Our Ref: EN010012

Date: 25 February 2021

Application by NNB Generation Company (SZC) Limited for an Order Granting Development Consent for The Sizewell C Project

Request for further information

DRAWING NO:
SZC-SZ0100-XX-000-DRW-100207

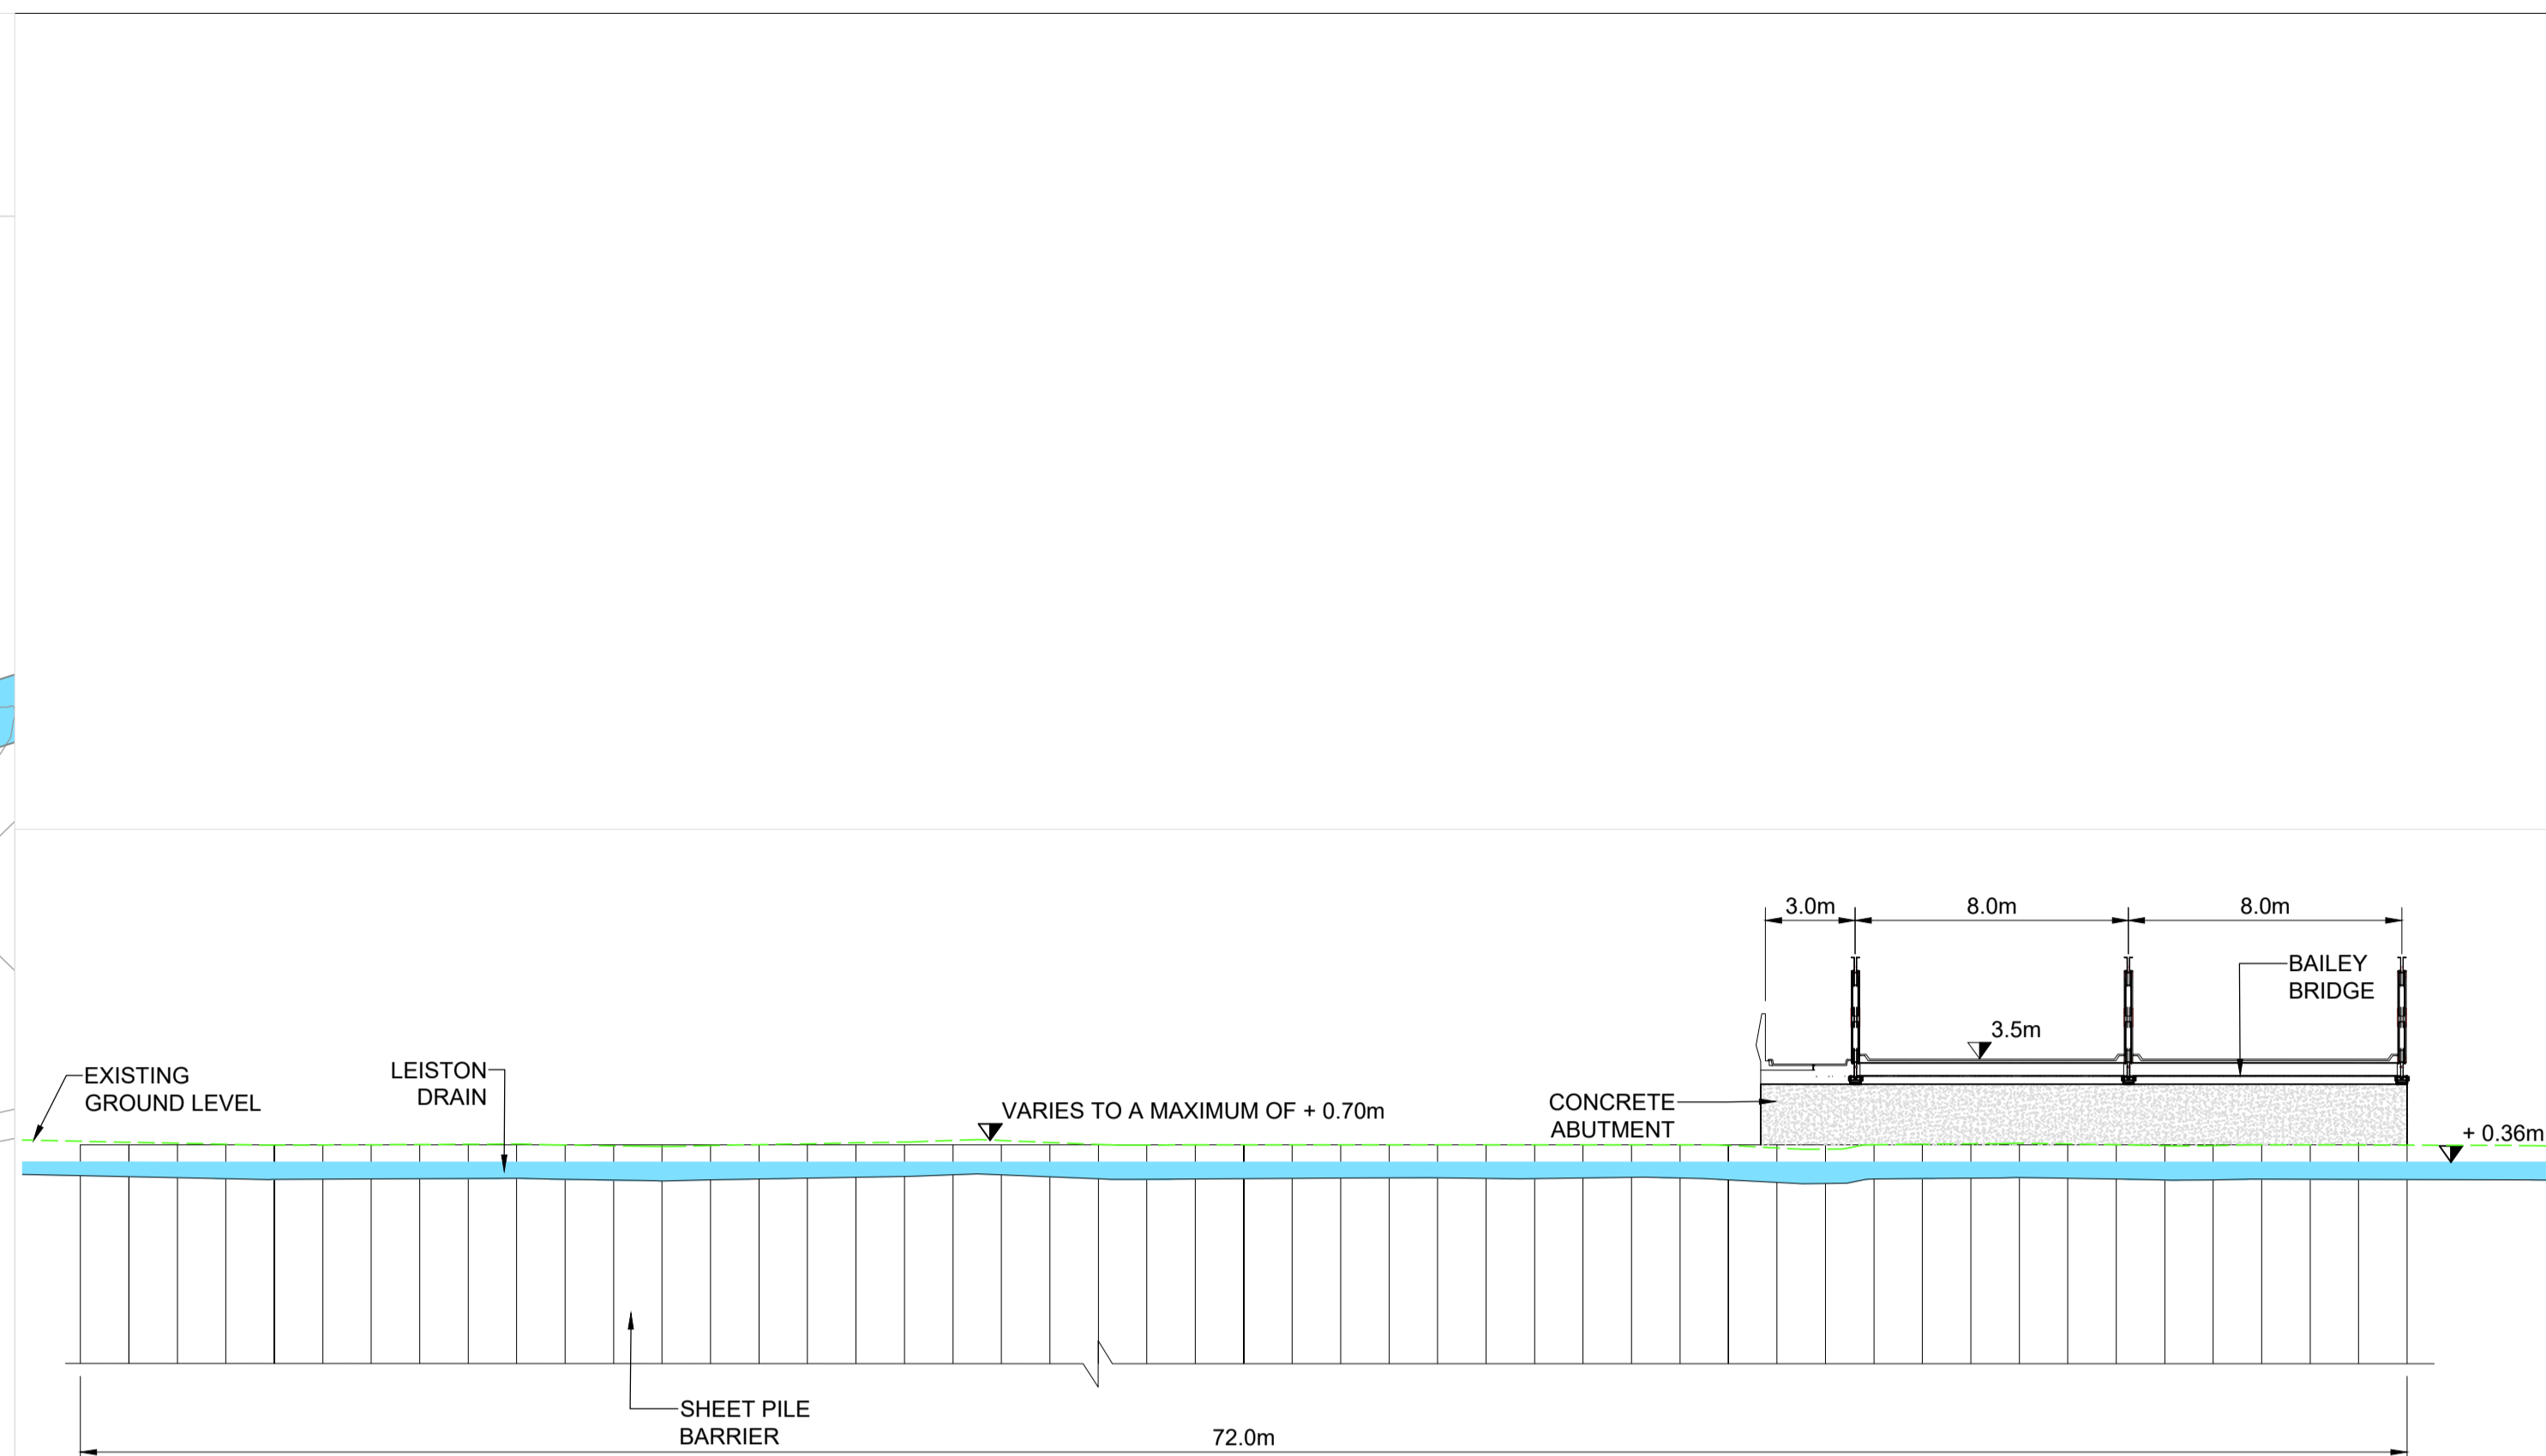
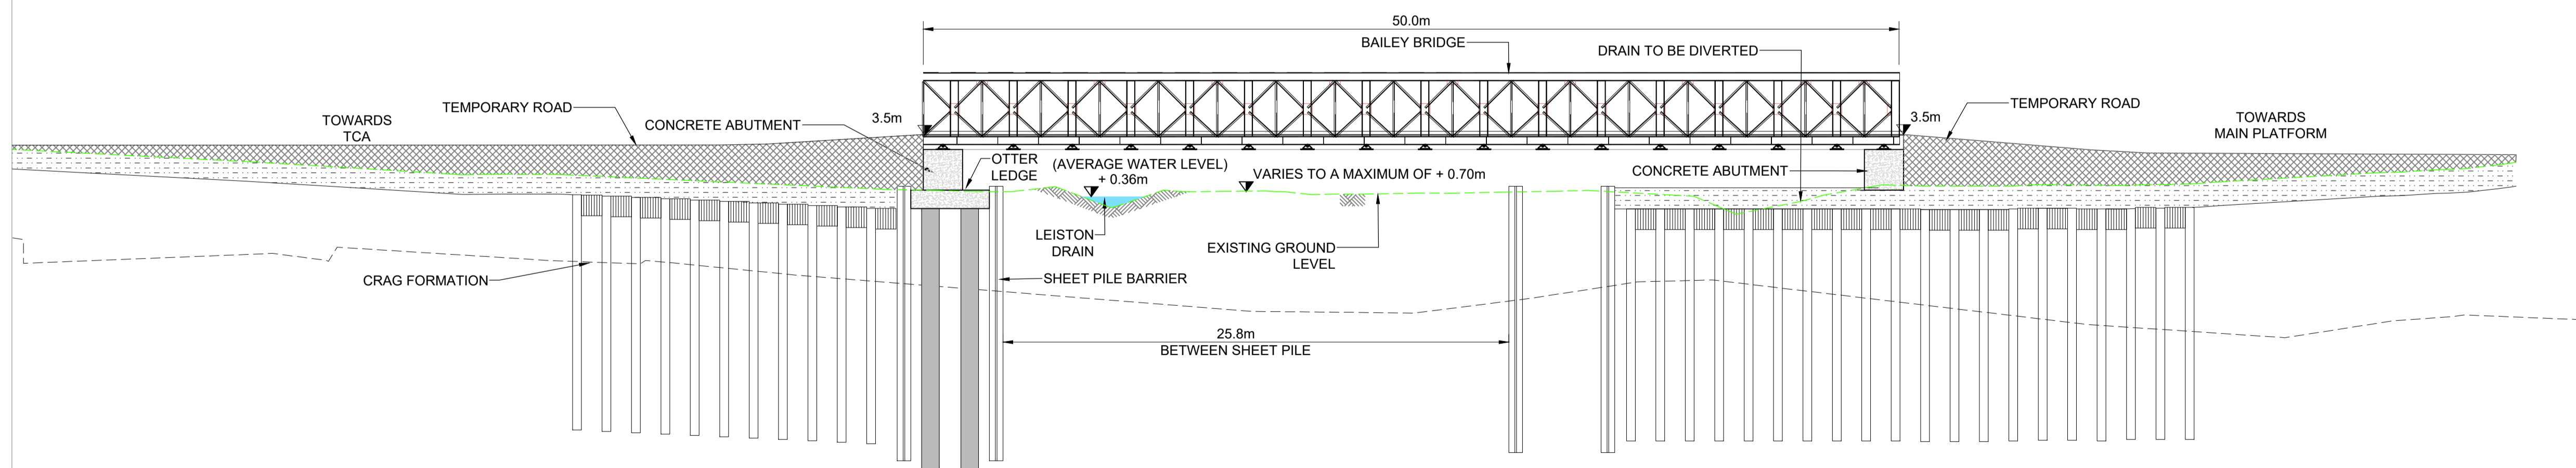
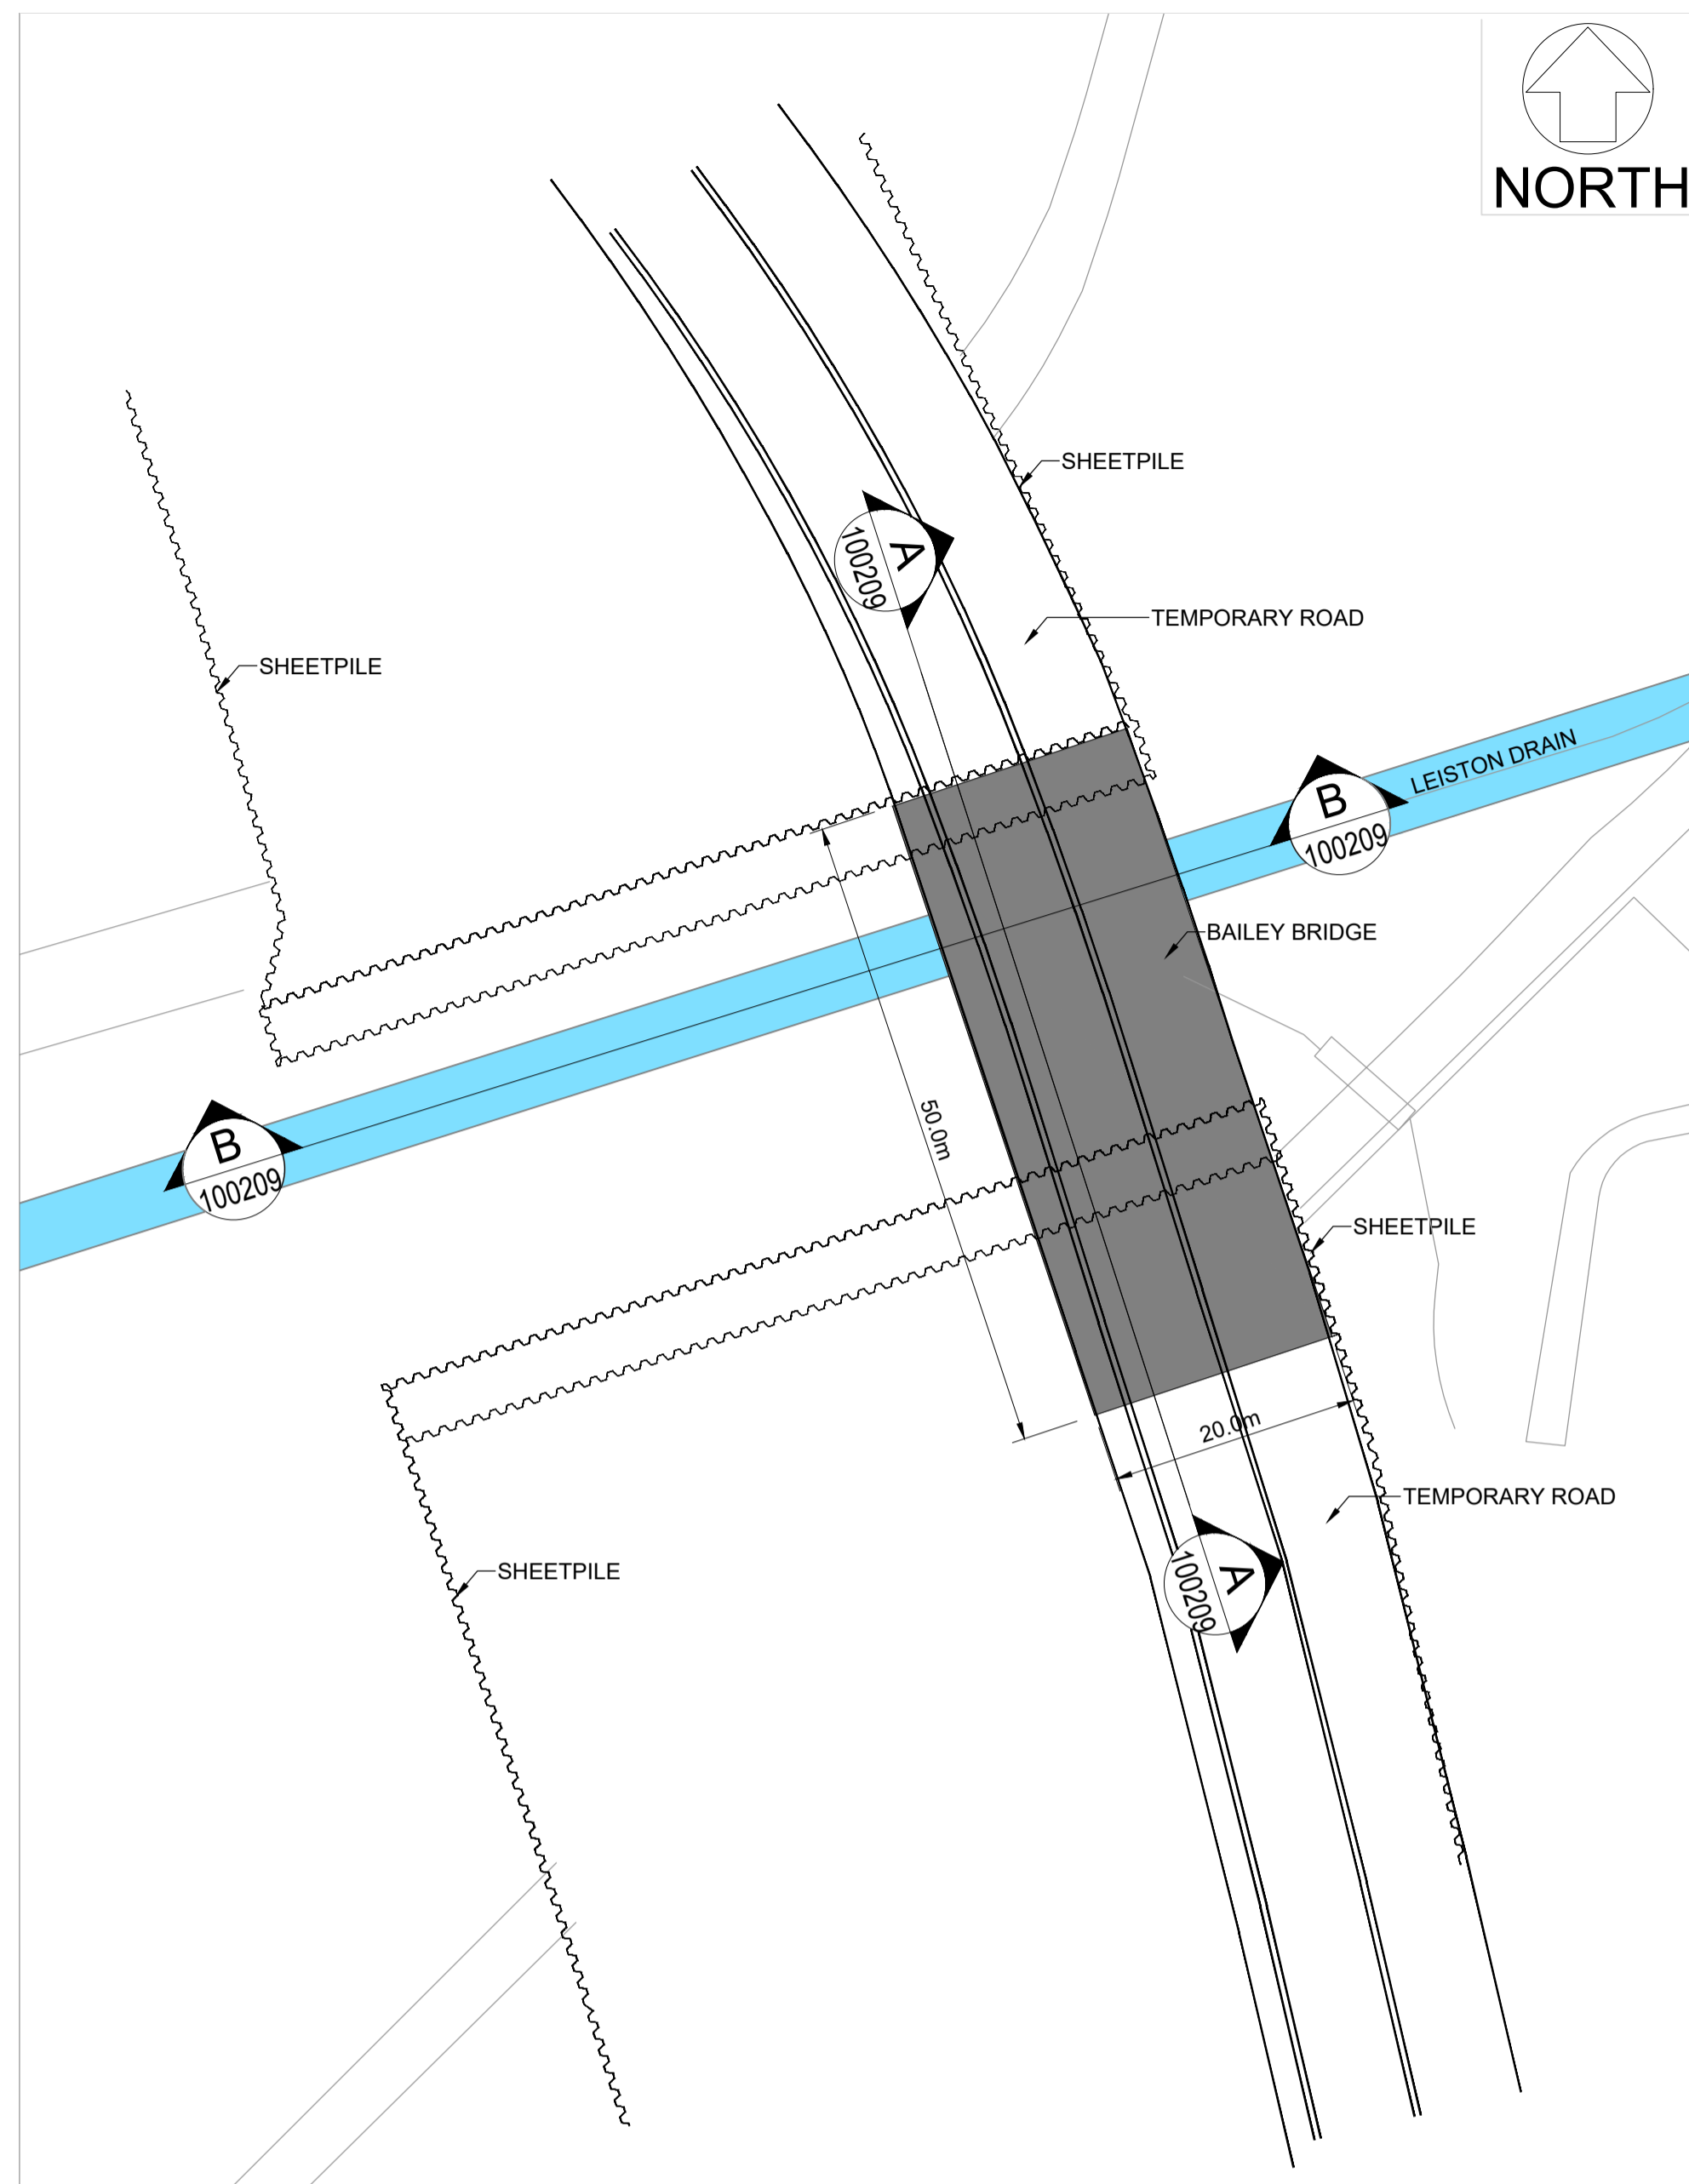
- A detailed plan of the permanent crossing of the SSSI and its connection to the main site;
- A detailed plan of the SSSI crossing showing the additional temporary haul road in place.
- A detailed plan showing the temporary bailey bridges
- A cross section perpendicular to the longitudinal section that is shown in Plate 3.2 in [[AS-157](#)];
- A permanent access road cross section showing the widths of carriageway and locations of the barriers to correct scale;
- A representative view / elevation of the crossing from the west side looking east; and
- If lighting is proposed to be provided a revised version of Figure 2.2.15 in [[AS-190](#)] and related views/ sections requested above.
